Access Design Assessment Report

ALEXANDRIA PARK COMMUNITY SCHOOL
7 PARK ROAD
ALEXANDRIA NSW 2015

Project: Alexandria Park Community School, 7 Park Road, Alexandria Park NSW 2015
Document Type: Access Design Assessment Report
Report Number: P216_282-3 (ACCESS) LD

5 LEVEL 4 FLOOR PLAN
1 : 1000

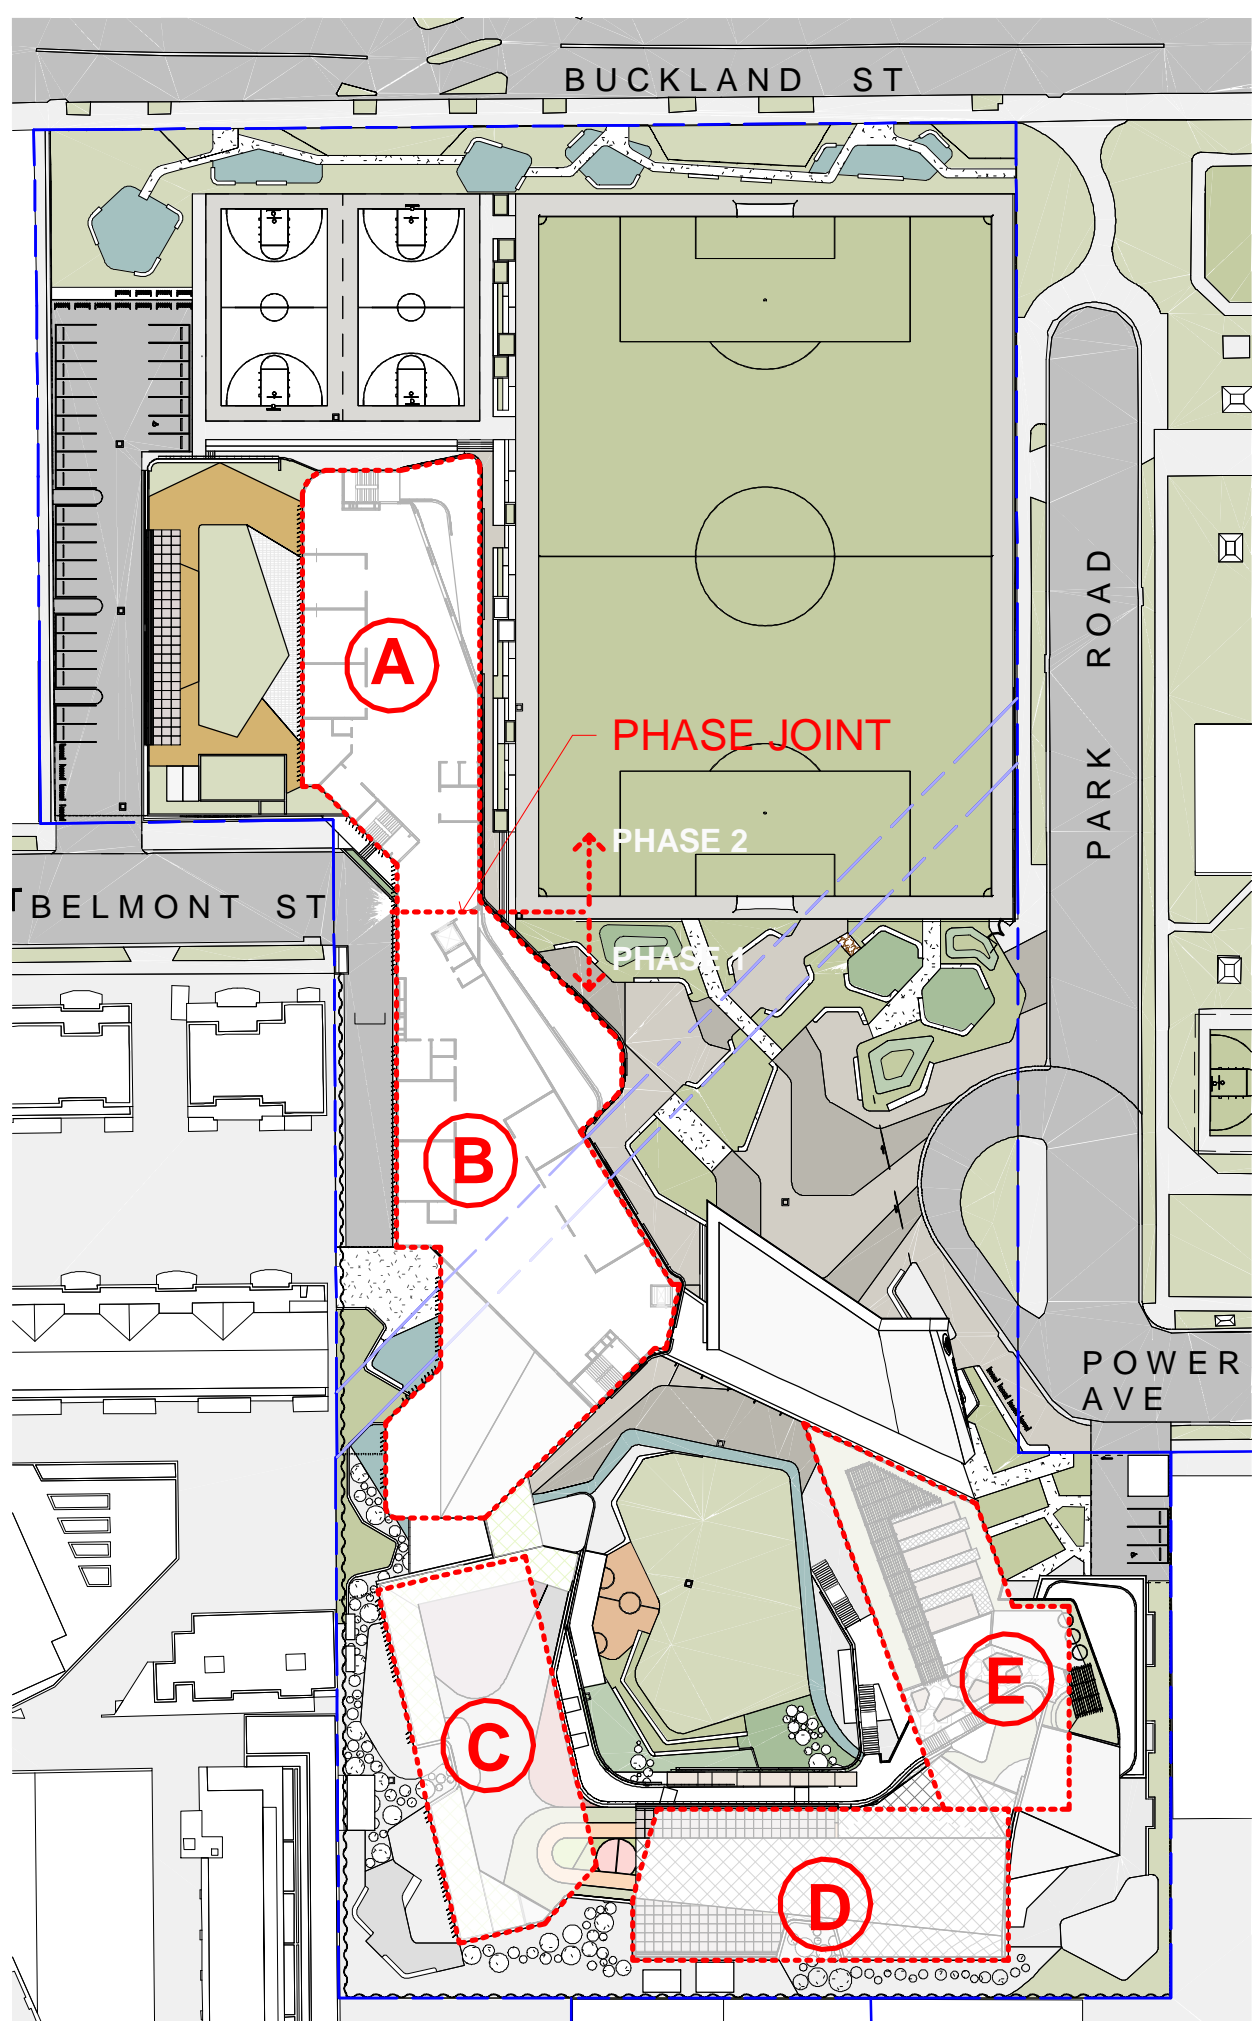
GROUND FLOOR

- Gym foyer - WC;
- Student reception – WC and Shower; and
- Preschool - WC and WC Shower.

FIRST FLOOR

- General learning unit 1 – WC and Shower;
- General learning unit 2 – WC and Shower; and
- Staff / admin – WC.

SECOND, THIRD, FOURTH FLOOR

- No accessible facilities have been provided on the second, third or fourth floor.

Provide one (1) accessible unisex sanitary compartment at each bank of male / female toilets on each storey.
